| Planning Application Reference: | 21/04166/F |
| Location Of Development: | The Pheasant Pluckers Inn Burdrop OX15 5RQ |
| Proposed Development Details: | Permission is sought to re-position and amend the structure of the previously allowed 3 bedroom building |

Comment for planning application 21/04166/F

**PAPER SIZE : A4
SCALE 1: 100
REVISED ELEVATIONS**

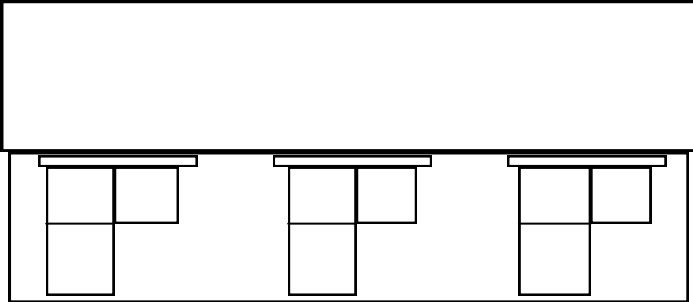
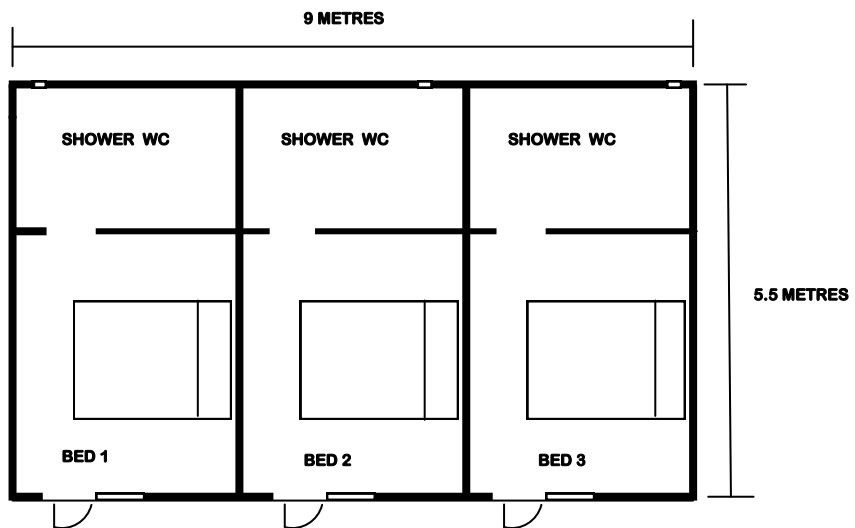
| Comments | <input boundary="" land."="" of="" on="" outside="" parking"="" public="" the="" type="text" value="An application for a different building in a different position must be a new application. If The Planners approve this, then measures should be put in place to ensure that it is permanently tied to the Public House. A situation should be avoided where both the letting rooms and the cottage are allowed. Any holiday letting rules should be strictly observed. The elevation drawings showing "/> |

| Comments | <input type="text" value="Further to the submission of my wife I make two additional comments. The sketches submitted fail to illustrate adequately the impact on the street view. The attached photo taken from the road through Burdrop, shows a view of the gable end of the grade II listed thatched barn from the street. The proposed construction would significantly obscure and amend to the detriment the view from the west on the lane. The application also contains a factual error as it states that there are no protected species on adjacent sites. A review of planning applications conducted for adjacent properties shows that two protected species of bat roost in the barn at the adjacent property. The local authority have a statutory responsibility to reject the application as a thorough ecological report has not been submitted with the application."/> |
